BEFORE THE HEARING EXAMINER OF THE CITY OF MERCER ISLAND

IN RE: NOTICE OF DECISION: FILE NO.
2207-019

Case No. APL24-002

APPELLANT DANIEL GROVE'S
CORRECTED PRE-HEARING
MEMORANDUM AND RESPONSE TO
DOROTHY STRAND AND THE CITY
OF MERCER ISLAND'S REQUEST
FOR DISMISSAL

4

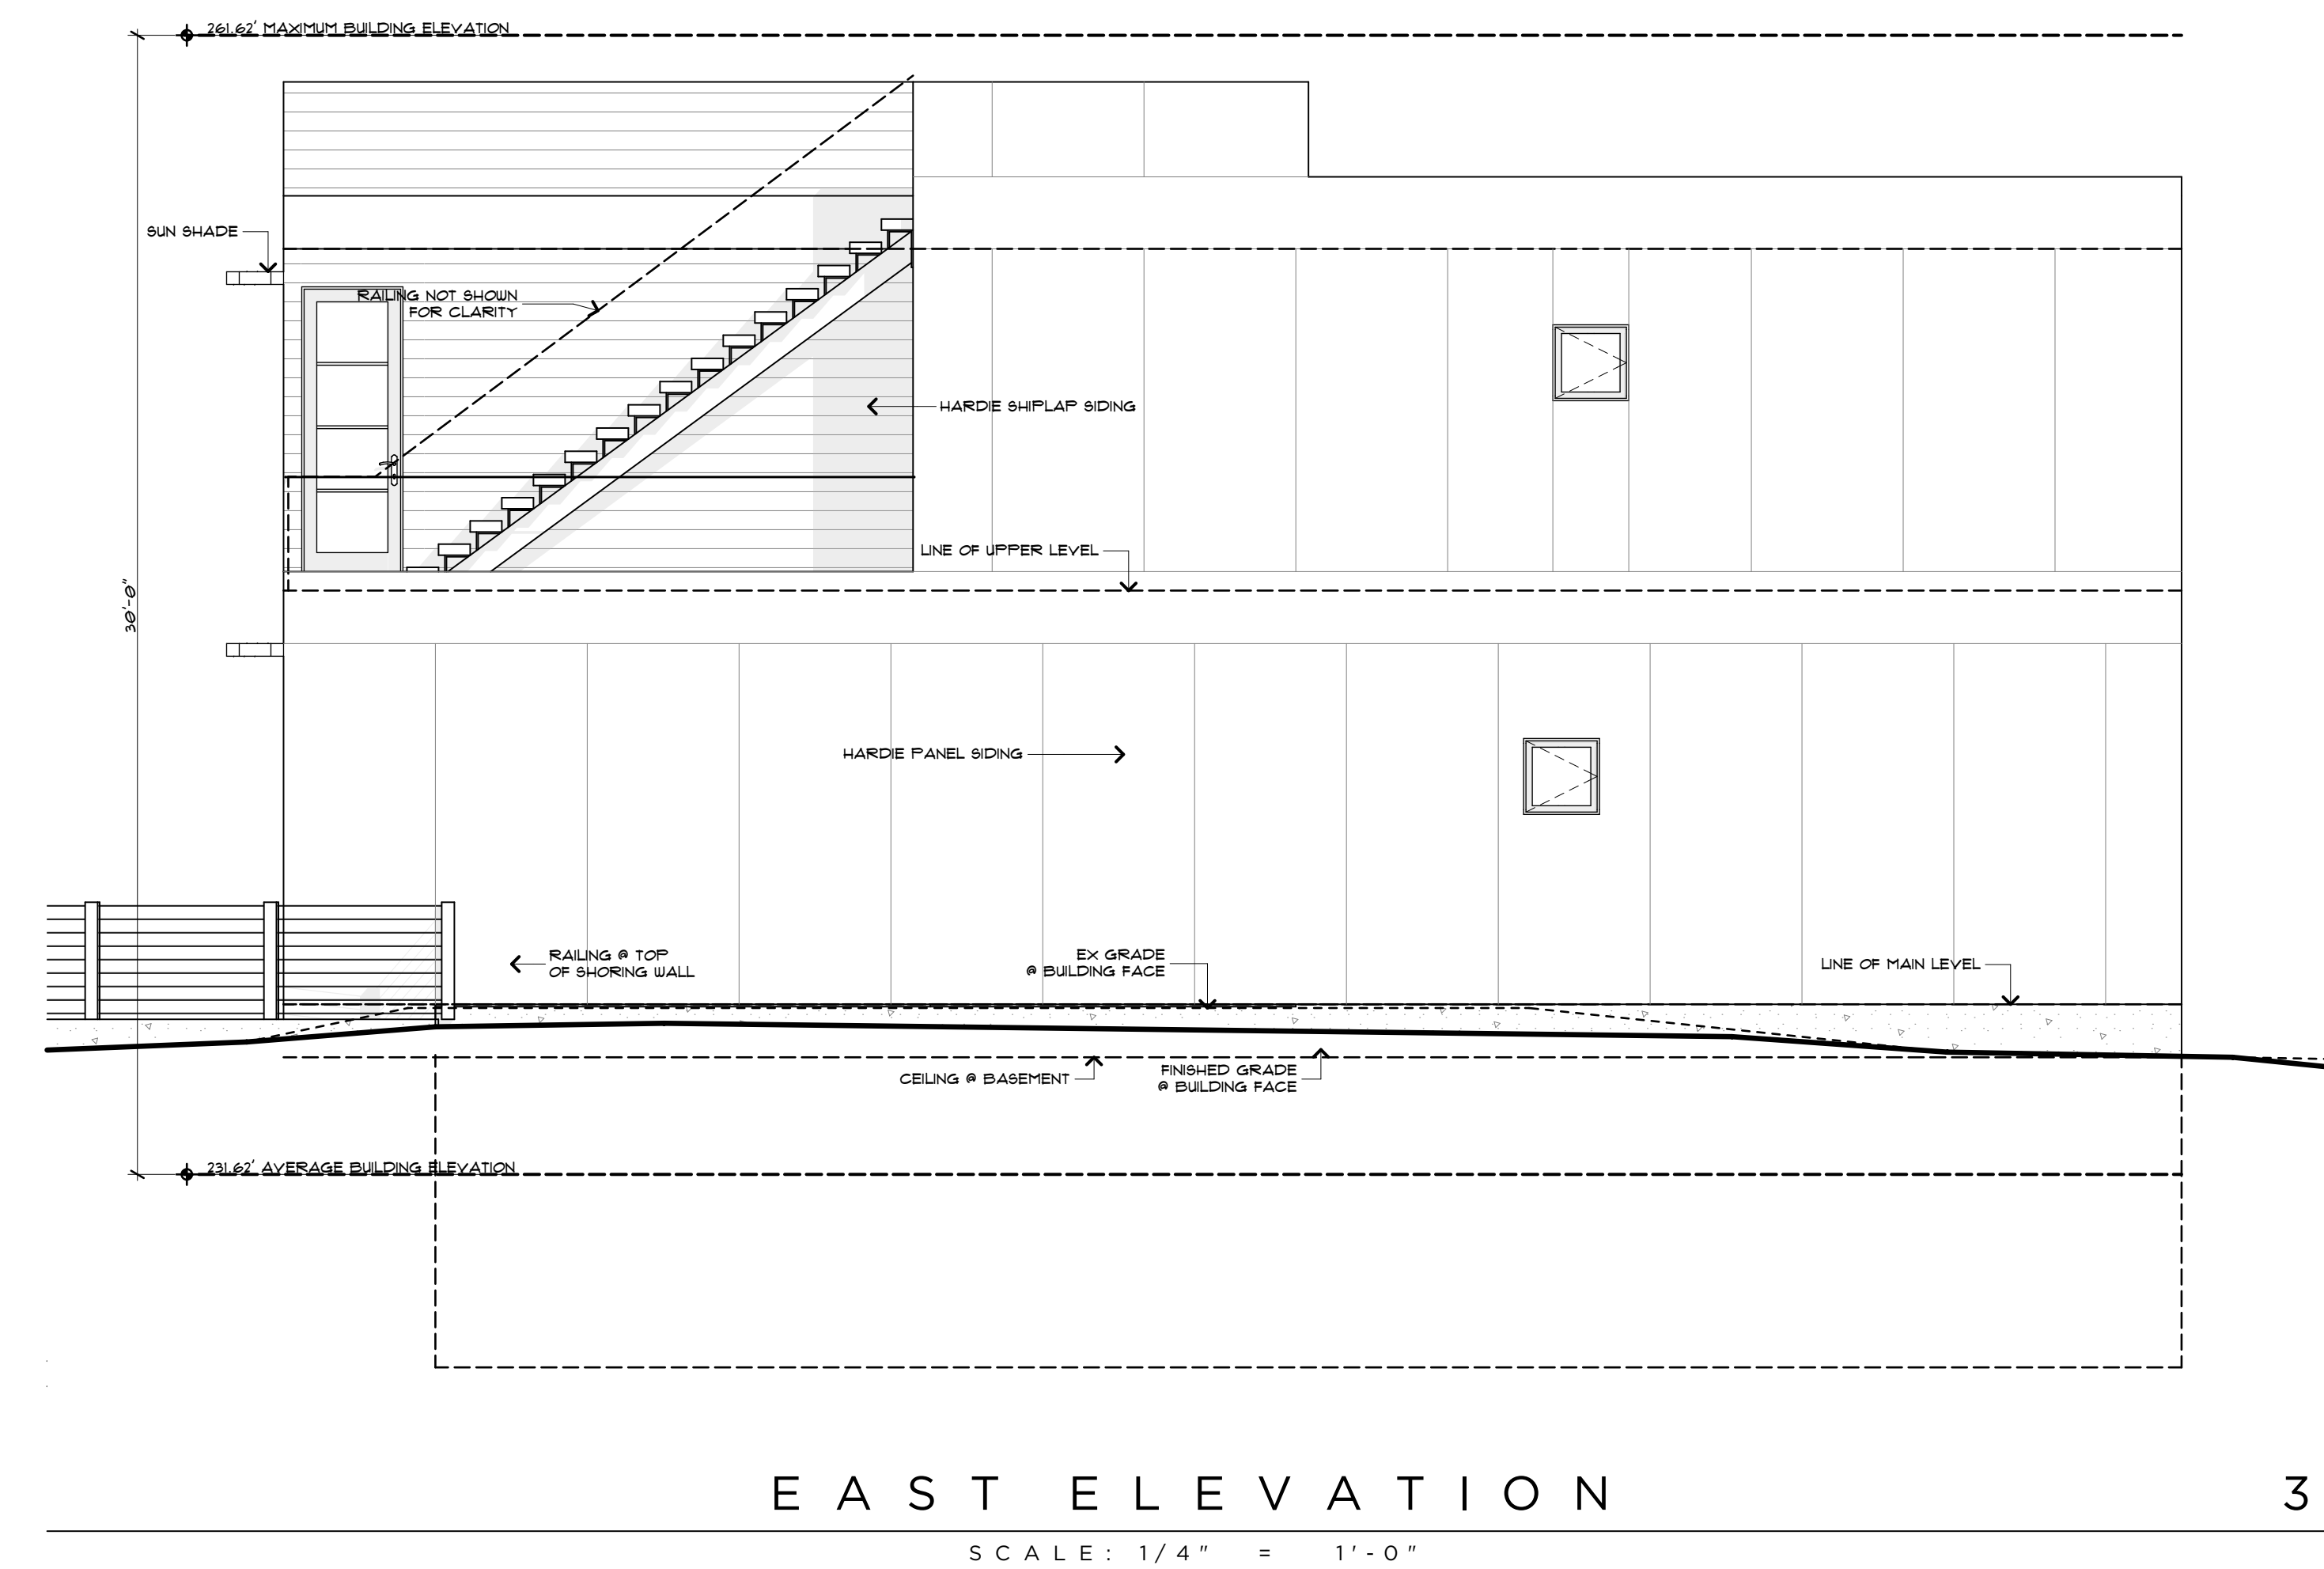
1 *whichever is lower, at the furthest downhill extent of the proposed*
2 *building*, to the top of the exterior wall facade supporting the roof
3 framing, rafters, trusses, etc.” Staff Report at 8. It is not disputed
4 that the property at issue in this case slopes downhill primarily from
5 east to west. The rooftop railings attached to the southern exterior
6 wall and the southern end of the western wall both exceed maximum
7 allowed heights.

8 Certain appurtenances may exceed that 30-foot height limit, but rooftop railings are not
9 one of them. MICC 19.02.020(E)(3)(b). *Id.* Ms. Strand appears to rely on a measurement from the
10 “Average Building Elevation” to determine a height of below 30 feet. *See* Strand Motion at 8. But
11 this is not consistent with the language of MICC 19.02.020.E., as explained above. The City
12 appears to rely on Ms. Strand’s inaccurate calculations to come to a similar conclusion that the
13 height has not been exceeded. Mr. Grove requests the Hearing Examiner review these
14 determinations and remand to the City for further consideration.
